I thank you for the opportunity to lodge a formal submission relating to the proposed Martins Creek Quarry Expansion Project.

- This project is classified as A State Significant Development (SSD) under the Environmental Planning and Assessment Act (1979) (Application Number SSD 6612).

BIODIVERSITY ASSESSMENT REPORT PREPARED FOR MARTINS CREEK QUARRY STATION STREET MARTINS CREEK prepared by Conacher Consulting Pty Ltd August 2016.

**TABLE 3.4  
FAUNA SURVEY EFFORT DETAILS**

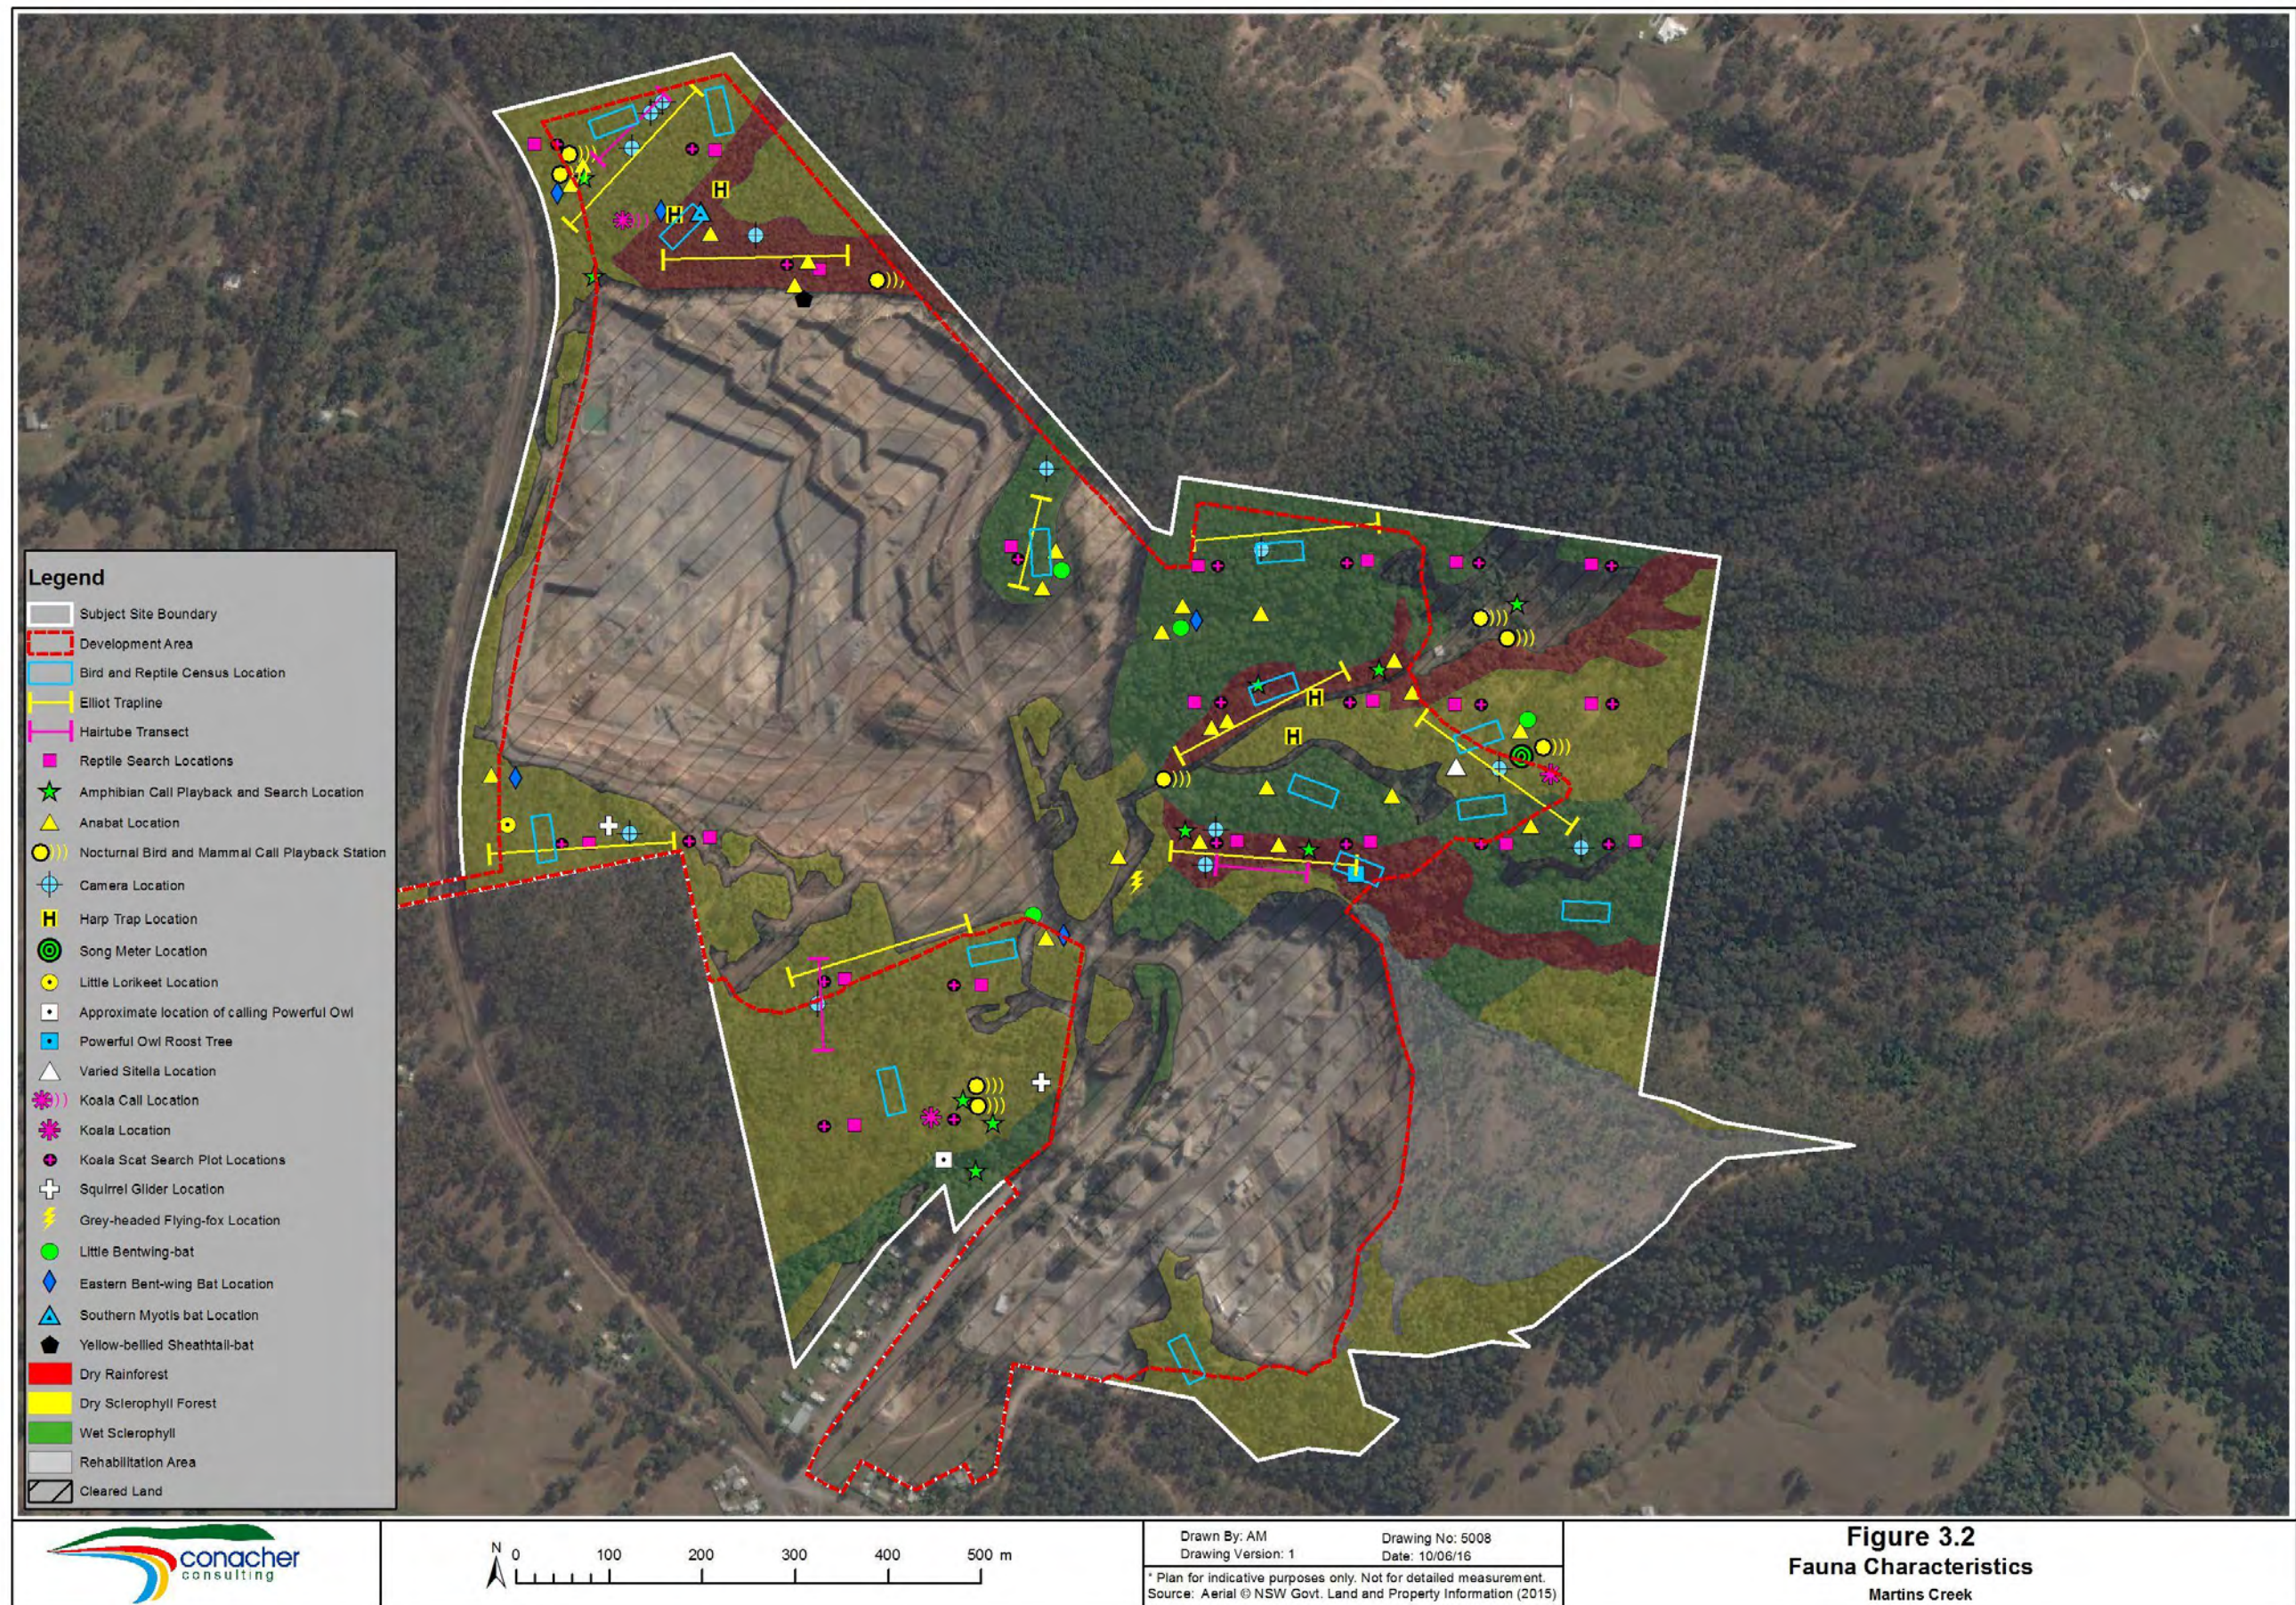
Table 3.4 On page 22 lists :- “Arboreal Mammal Elliot Trapping” was undertaken over the 15th Sept. -17th Sept. 15

In table 3.4 on page 22 under methodology for Arboreal Mammal Elliot Trapping, survey undertaken states :- “6 traps per transect .” giving a total 54 traps [6 traps X 9 transects].

4 transects in Dry Sclerophyl Forest.	[32.59 ha of this habitat type shown on page 14]
3 transects in Dry Rainforest	[8.44 ha of this habitat type shown on page 14]
2 transects in Wet Sclerophyl Forest.	[16.05 ha of this habitat type shown on page 14]

All transects are shown as straight lines

Four of the transects are shown as immediately adjacent to the existing quarry workings [one transect is shown as intersecting the quarry workings]

A portion of 3 transects are 20 to 30 metres from the existing active quarry periphery [estimated from the scale bar on the the bottom of the image]. Approximately 80 metres of another transect is shown as being within the existing quarry workings.

Based upon the scale bar on the bottom of the image, eight of the transects are 200 metres long and one is 100 metres long.

For the 200 metre transects, this means one Elliot trap every 33 metres

For the 100 metres transect, this means one Elliot trap every 16.5 metres

- For a 32.59 ha of Dry Sclerophyl Forest habitat, 800 linear metres were surveyed.

- For an 8.44 ha of Dry Rainforest habitat, 600 linear metres were surveyed.
- For a 16.05 ha of Wet Sclerophyl Forest habitat, 300 linear metres were surveyed.

- **I contend only a very small portion of each flora community was actually examined, biased to linear strips within each community.**
- **This over 3 nights only.**
- **I concede supplementary spotlighting was done, but, I am of the opinion that any data regarding species habitation is not a definitive representation of the actual situation.**
